Ribble Valley Borough Council
Housing & Development Control

Application no: **3/2024/0262**

Address: **Burnhouse Farm Back Lane Slaidburn BB7 3EE**

Proposal: **Regularisation of change of use from agricultural land to the siting of three camping lodges, decking, hot tubs and septic tank with associated landscaping works.**

Proposed Site Plan
Scale (1 : 5 0 0)

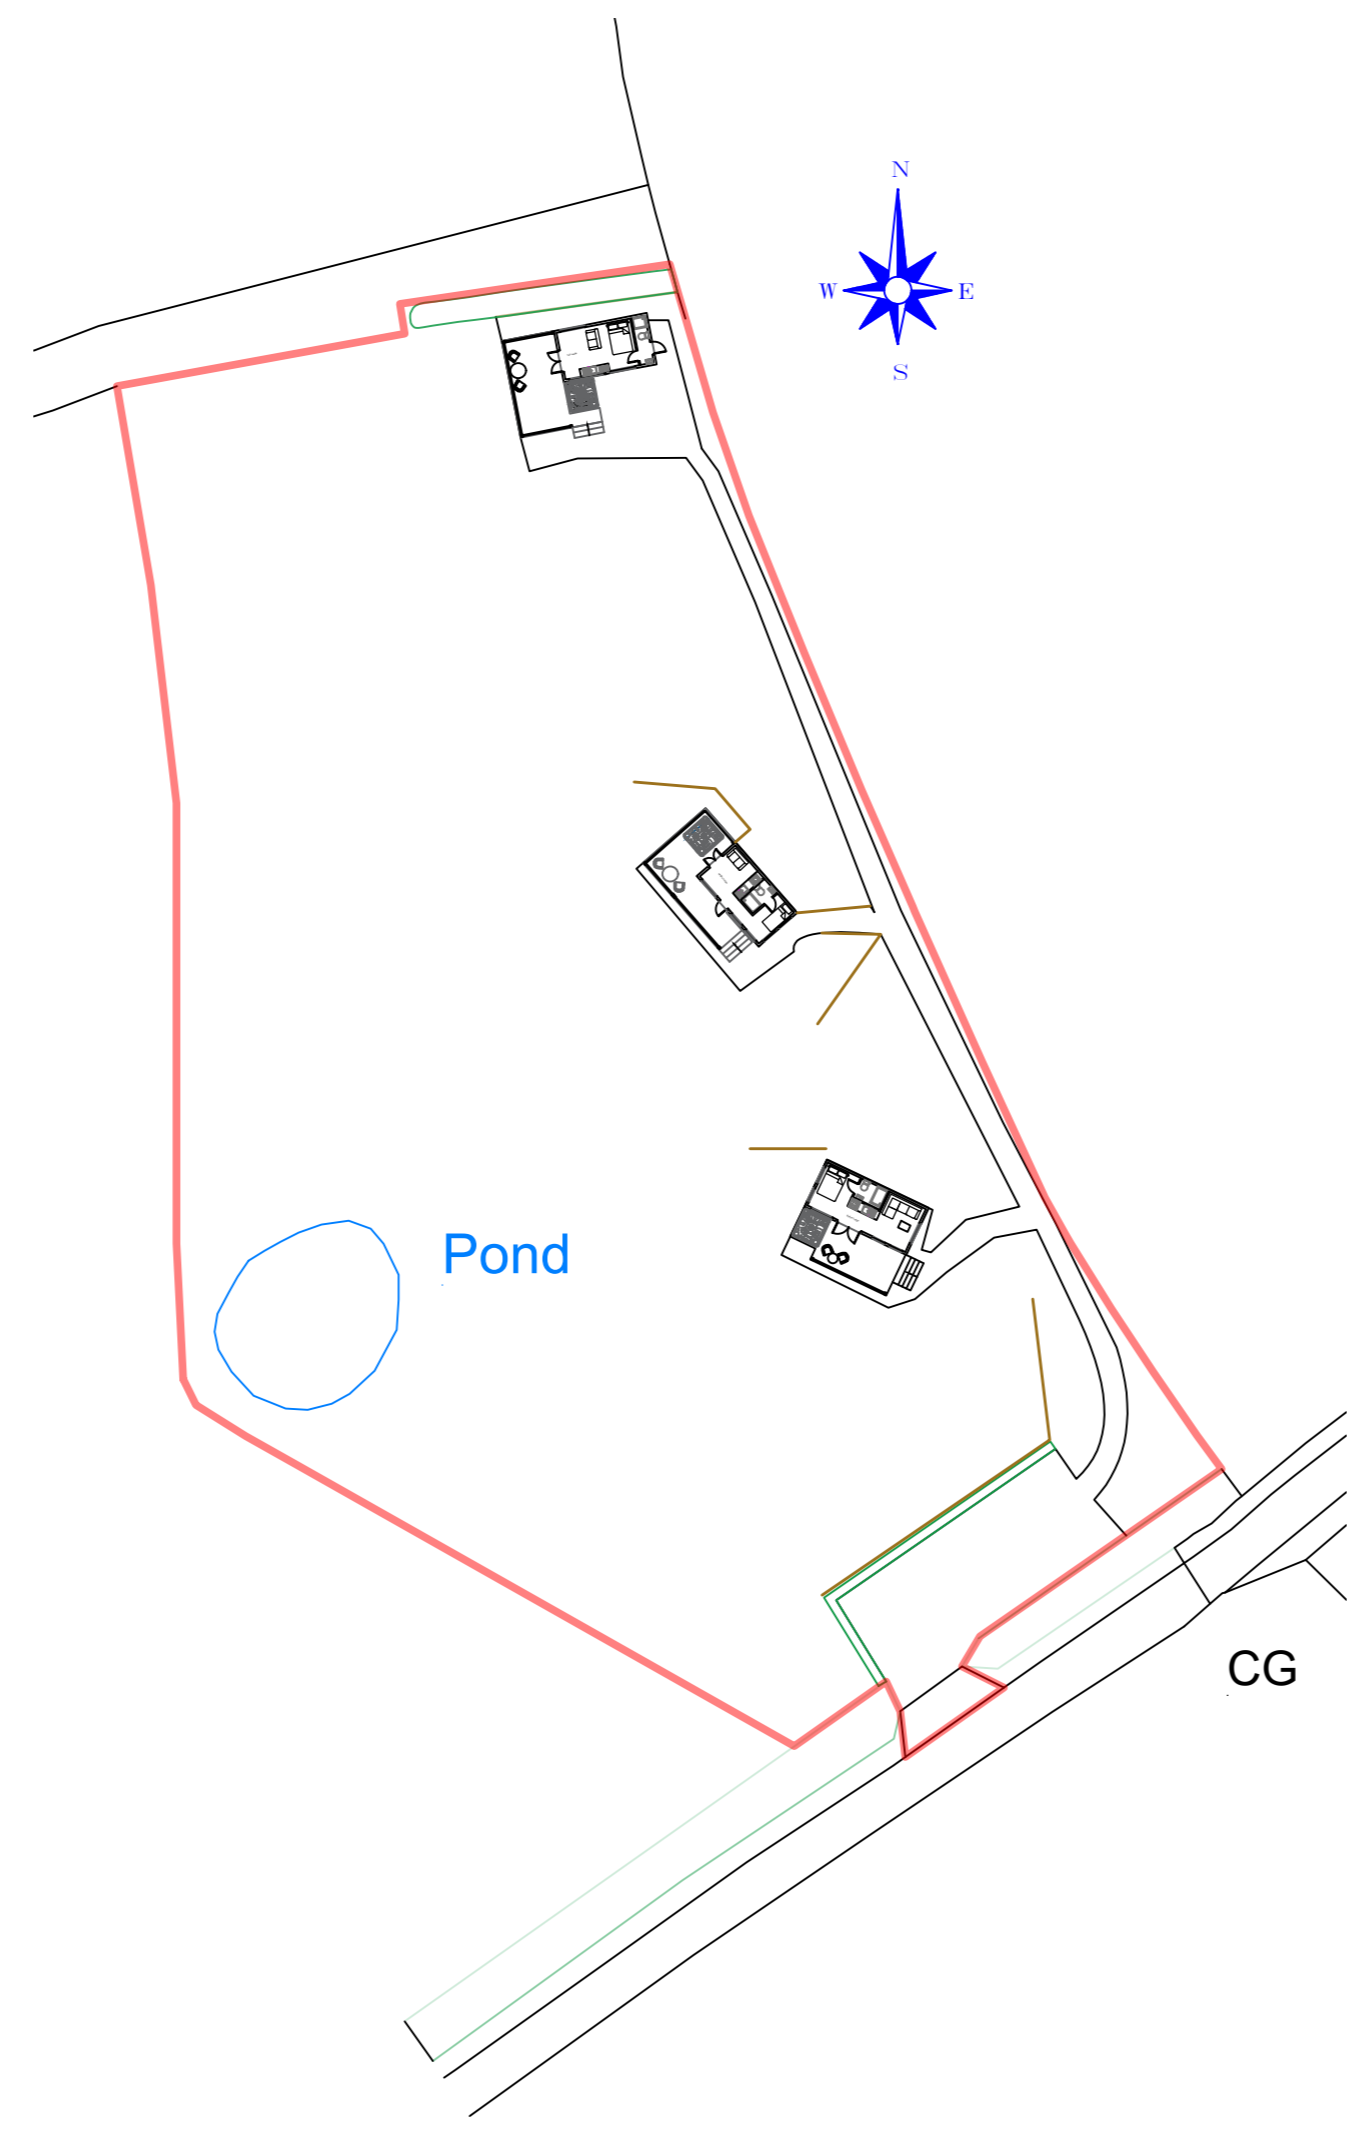
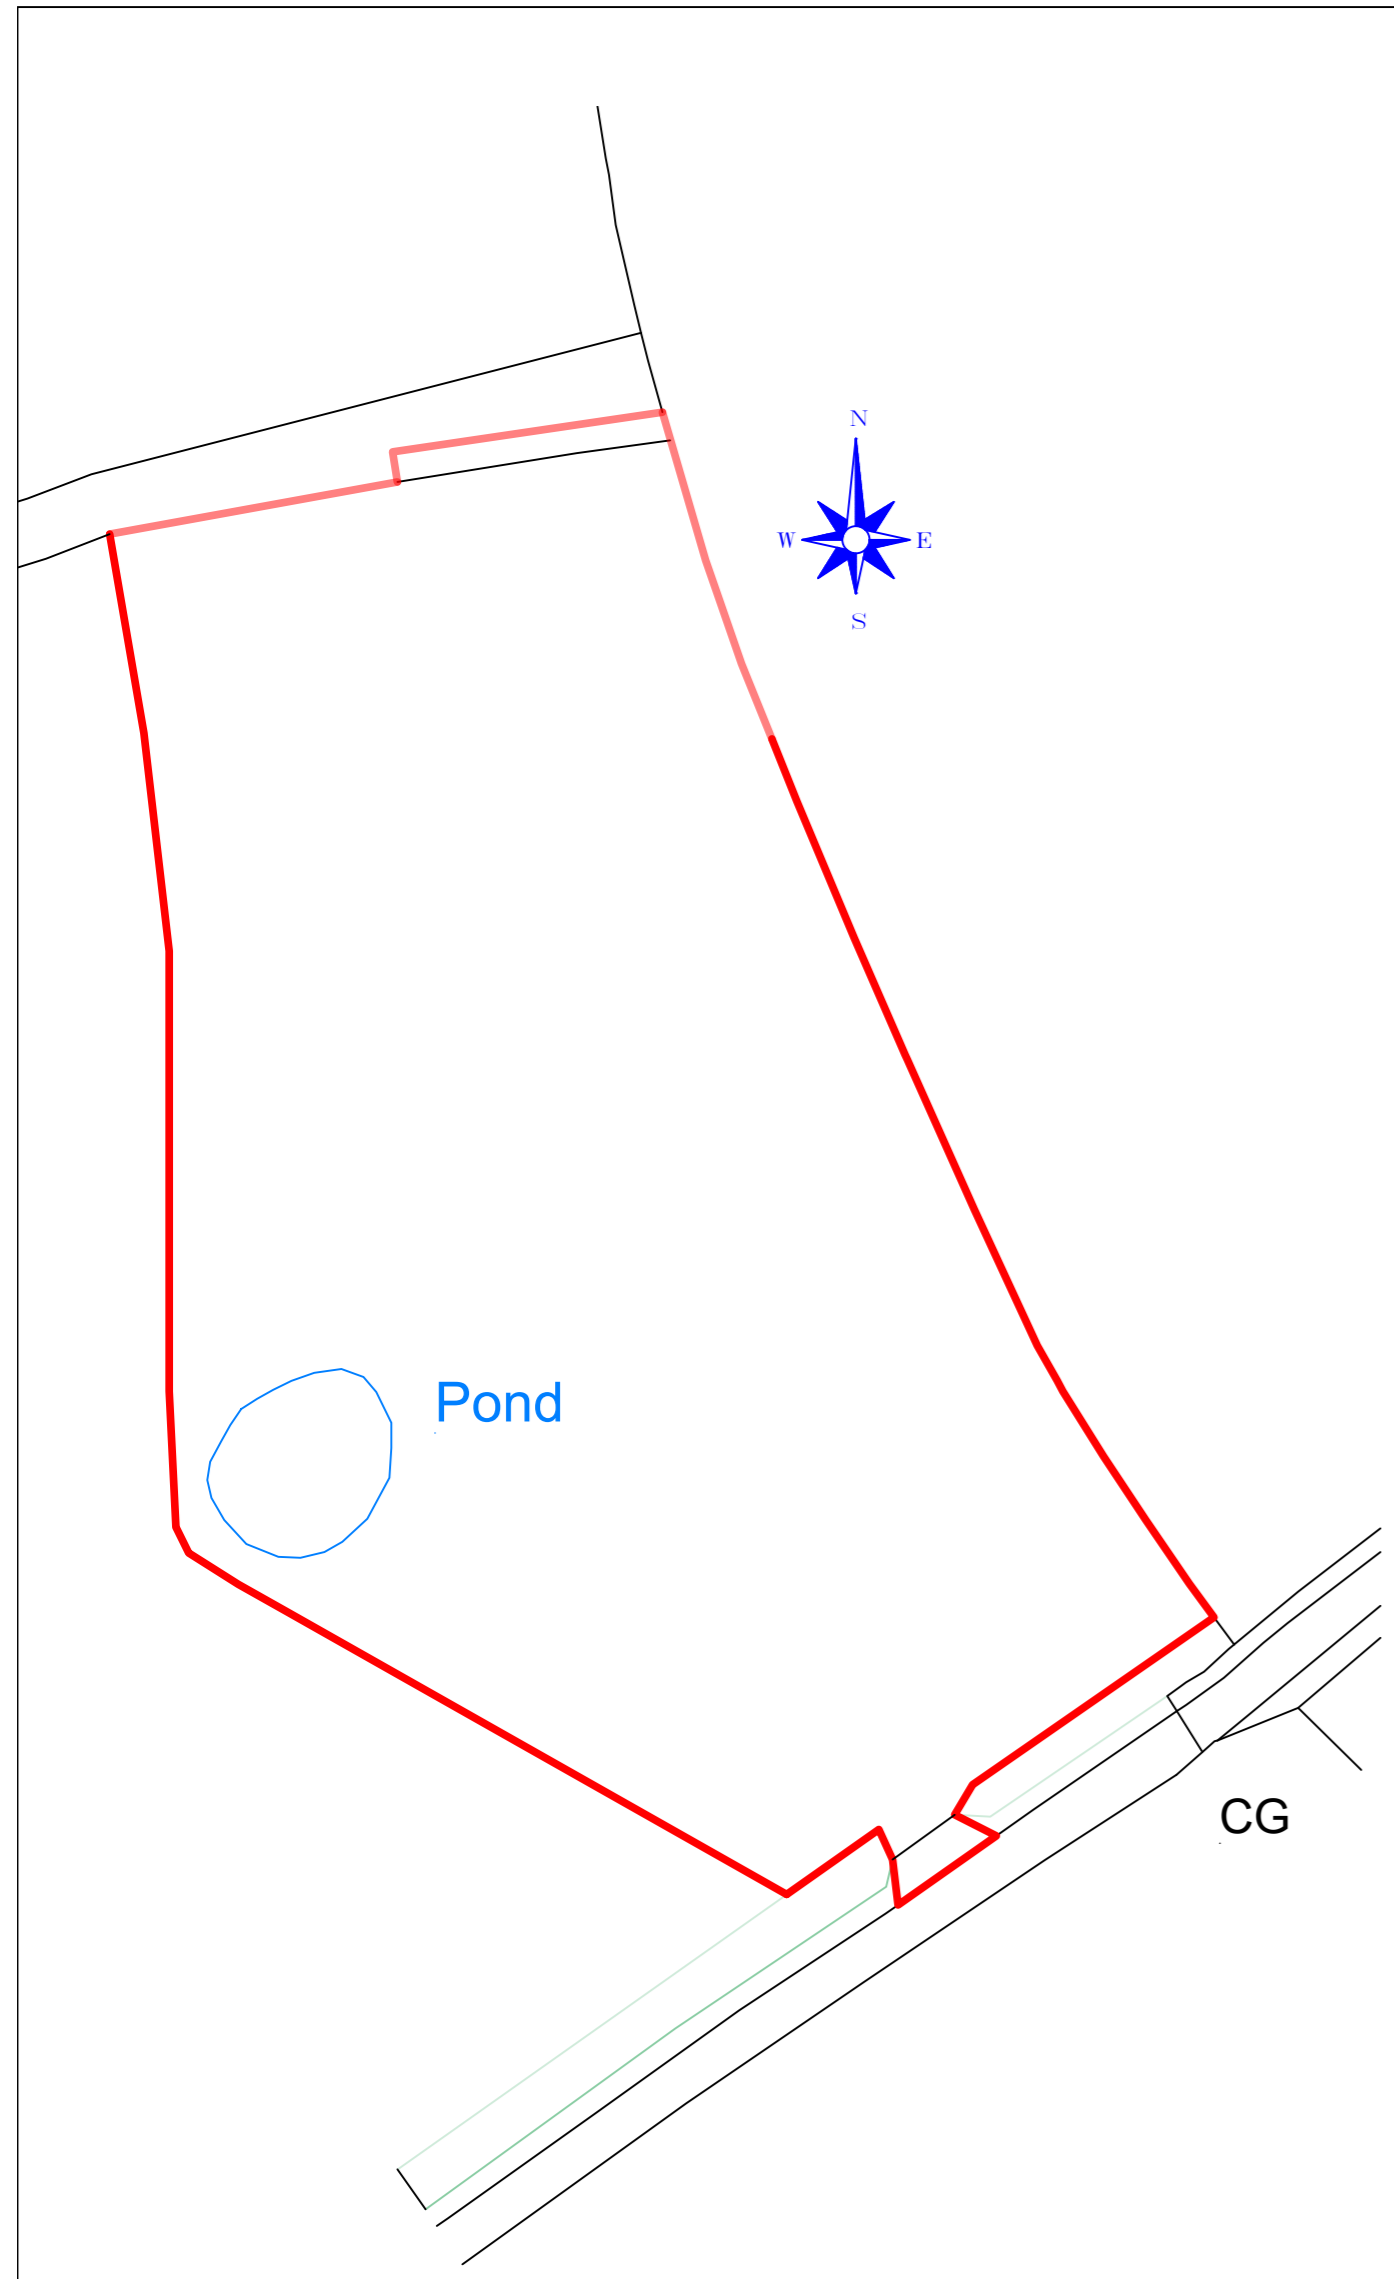
As shown on MacMarshalls drawing number C193-5-001 titled "Site Plans" a car parking area for a minimum of 3 car parking spaces has been provided. These parking arrangements comply with the LHAs parking guidance as defined within the Joint Lancashire Structure Plan for 3x 1 bed holiday lets.

The LHA will condition that a minimum of one car parking space has access to an electric vehicle charging point and some form of cycle storage provision is provided for the 3 units.

1. The development hereby permitted shall not be occupied until such time as the parking and turning facilities have been implemented in accordance with MacMarshalls drawing number C193-5-001. Thereafter the onsite parking provision shall be so maintained in perpetuity.

2. Prior to the first occupation a minimum of one car parking space shall have an electric vehicle charging point. Charge points must have a minimum power rating output of 7kW, be fitted with a universal socket that can charge all types of electric vehicle currently.

3. No building or use hereby permitted shall be occupied or the use commenced until a cycle storage plan for the holiday let units has been submitted to the Local Planning Authority, in consultation with the Local Highway Authority. These cycle facilities shall thereafter be kept free of obstruction and available for the parking of bicycles only at all times.
